## PREFERRED PROJECT REPORT

This Preferred Project Report (PPR) sets out the changes to the project since exhibition, arising in part from submissions made, and from further consultation with stakeholders including community representatives, the City of Sydney Council, and Dragon Boats NSW.

The changes to the project are:

BANK ST, PYRMONT NAVIGATION
IMPACT ASSESSMENT
PROPOSED MARINA BERTHING PLAN
MAP 5

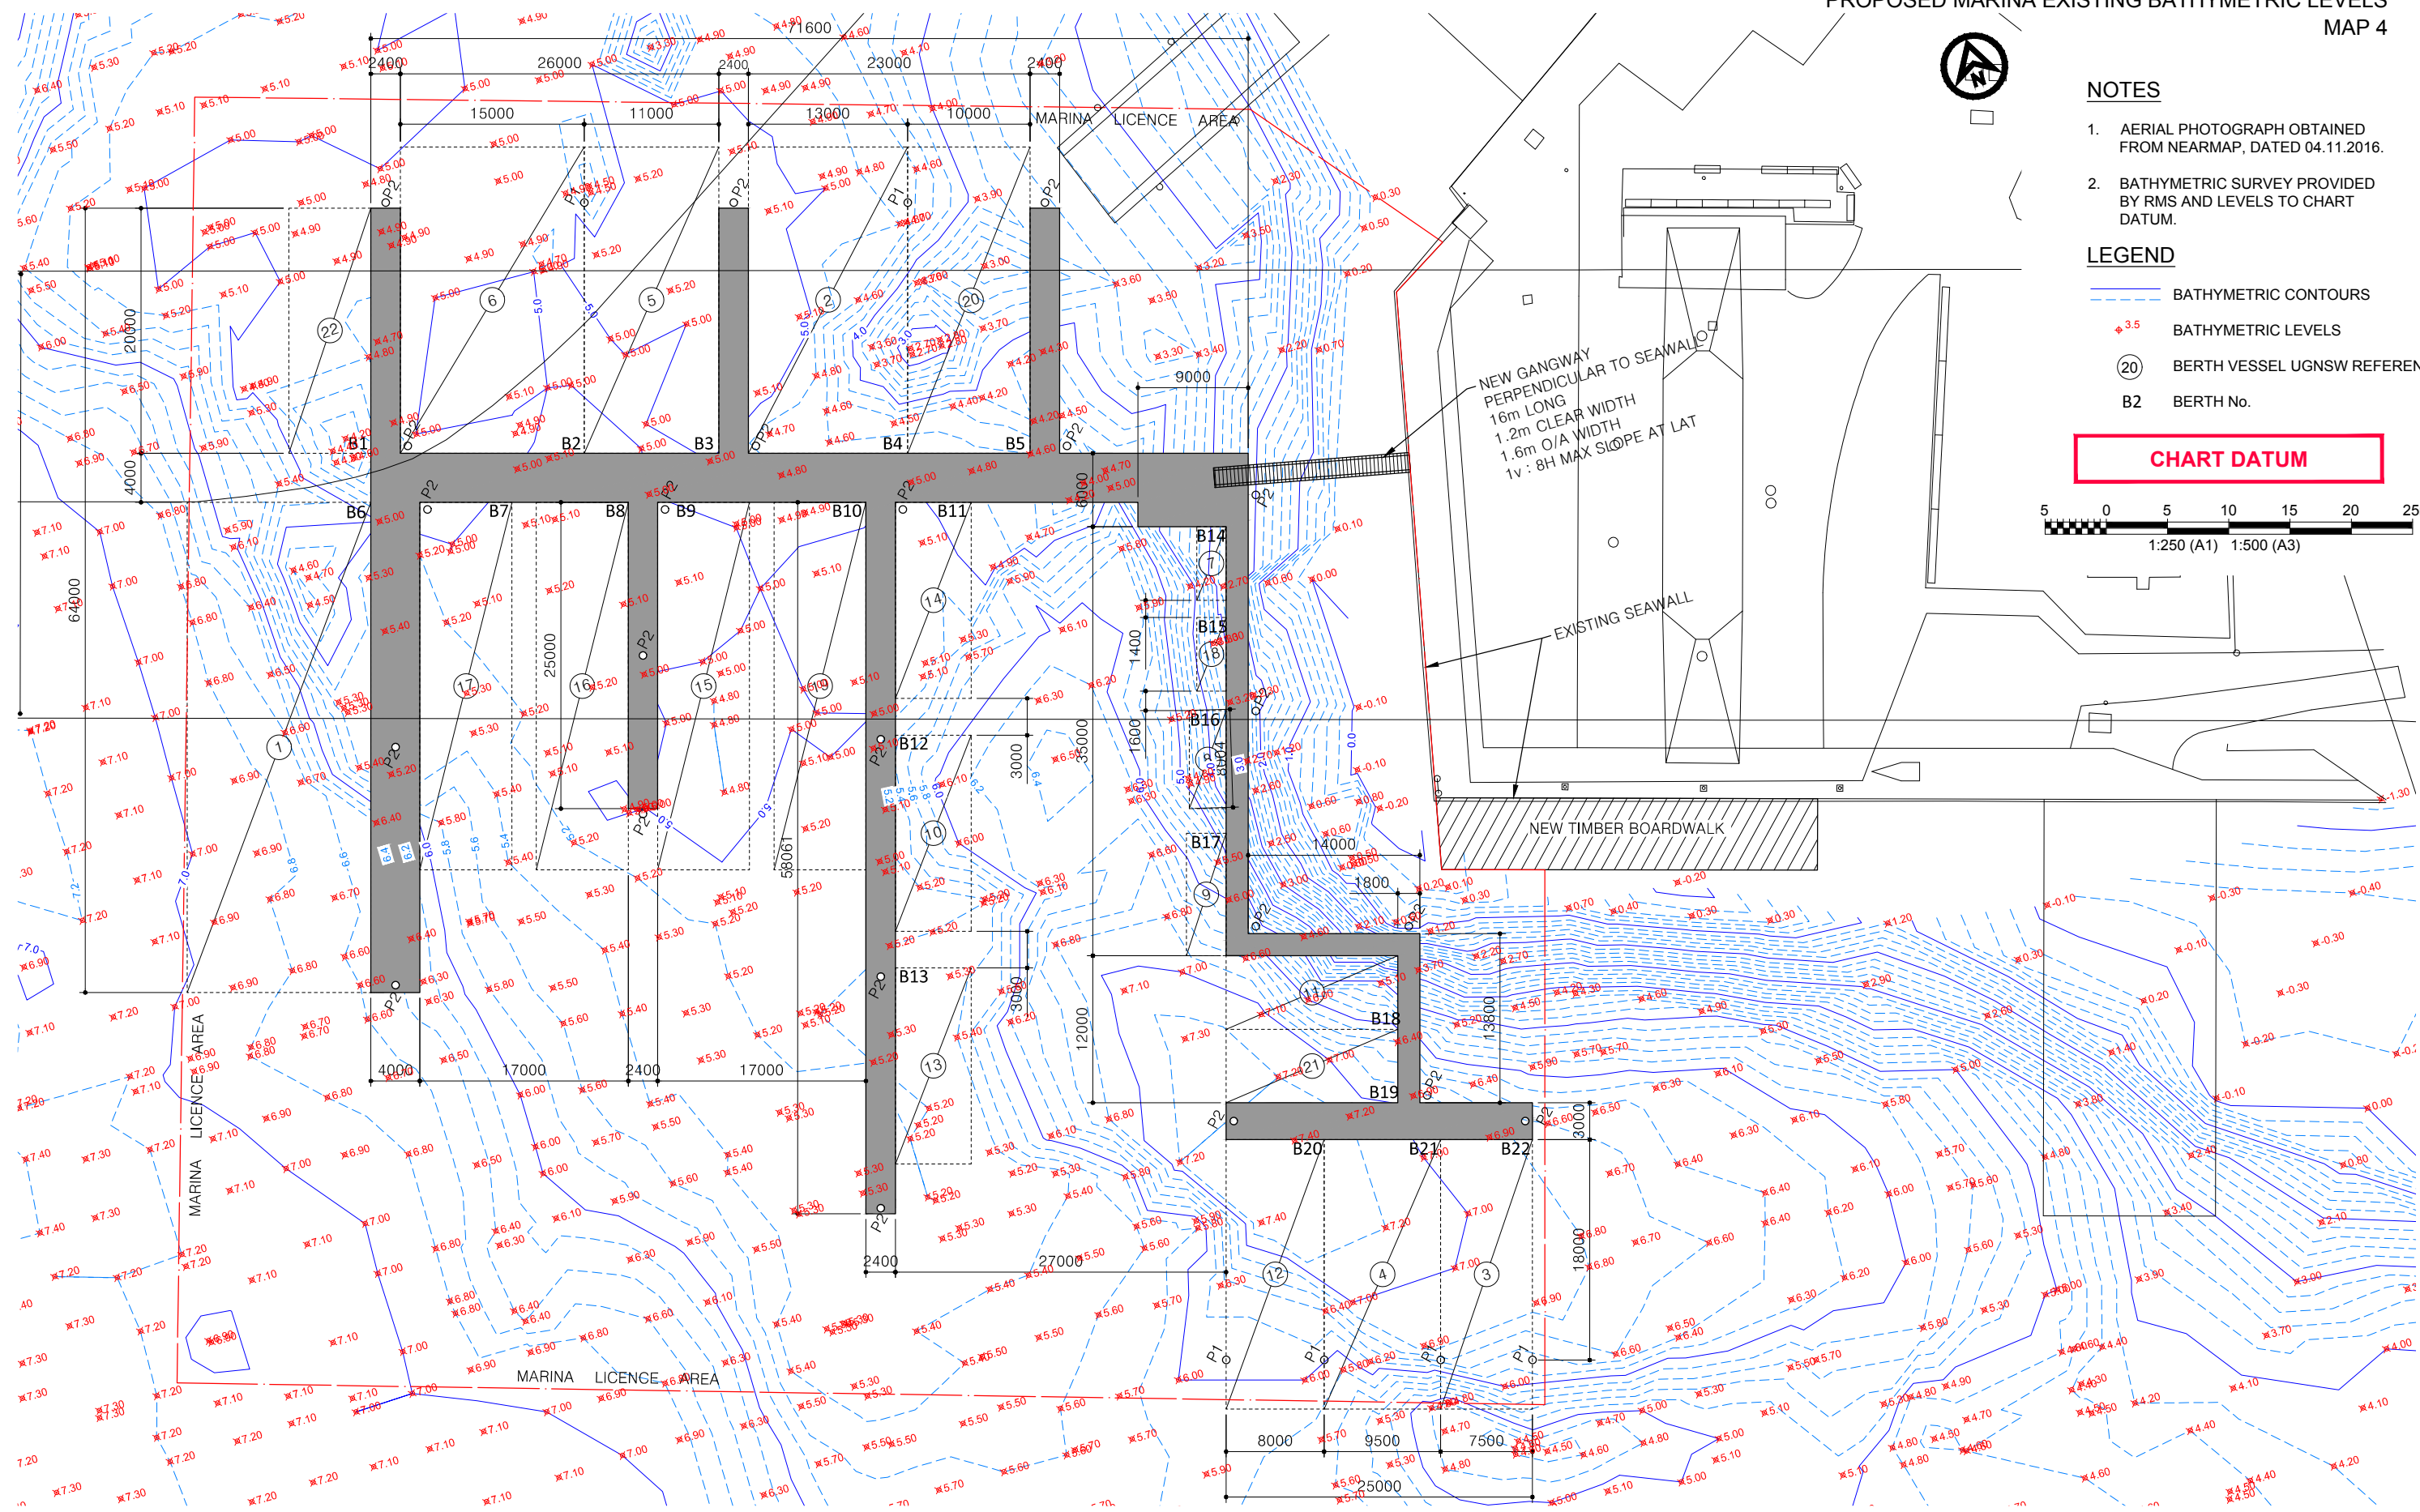
- Floating pontoons to comprise the marina instead of the originally approved fixed wharf;
- Reconfiguration / location of water-based structures, maritime safety devices, and the mooring arrangements;

The positions of vessels have been amended (as compared to the proposed berthing positions within the s75W Modification Application under the fixed wharf arrangement). This now provides a more efficient berthing / mooring arrangement and reduces interaction and conflict with the Dragon Boat launching ramp to the east. The reduced piling requirement for the floating structure also reduces impacts on the seabed during construction. Appropriate placement of vessels will further reduce seabed disturbance compared to the notional mooring arrangements under the fixed wharf design during operation of the marina.

- the 3 berths in the south-east corner of the marina are aligned approximately in a SSW-NNE direction (parallel to the dragon boat launching ramp) such that movement of marina vessels into and out of these berths would not involve manoeuvring in close proximity to the launching ramp;

- larger sized vessels with higher powered engines, are located in berths that are positioned away from the south-east corner of the marina and hence away from the dragon boat launching ramp;
